# Heckington Fen Solar Park

## Schedule of Changes to the draft Development Consent Order

Document Reference: PreExA.Sch-DCO.s55.v1

March 2023

DATE	SCALE	SHEET	REVISION
24/01/2023	1:2,500@A1	5	.

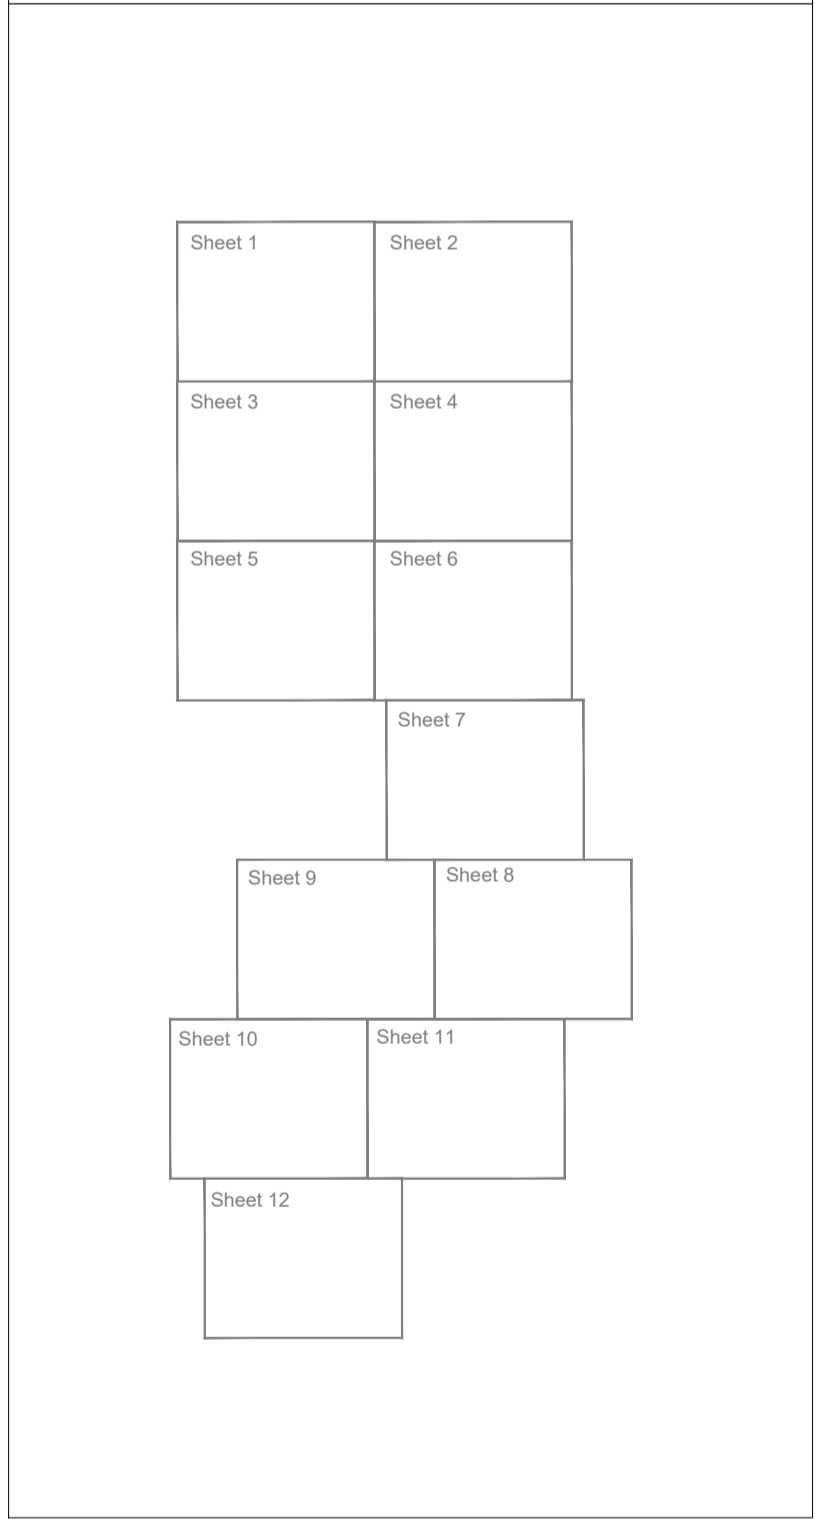
1.	Schedule 7	The Planning Inspectorate (PINS)	As part of their section 55 advice, PINS raised a question on the colouring on the Street and Access Plan (document reference 2.7). As a result, the Applicant has updated the description in the DCO for clarity.	<p>Part 1 has been updated as follows:</p> <p><i>"The provision of a permanent means of access to the authorised development from the north side of the A17, at point EP/B and the area <del>hatched</del> coloured pink on sheet 5 of the streets and access plan"</i></p> <p>Part 2 has been updated to refer to the area coloured purple rather than hatched blue as follows:</p> <p><i>"The provision of a temporary means of access to the authorised development from the north side of [the A17], at point [EP/A] and the area <del>hatched-blue</del> coloured purple on sheet [5] of the streets and access plan"</i></p>	2
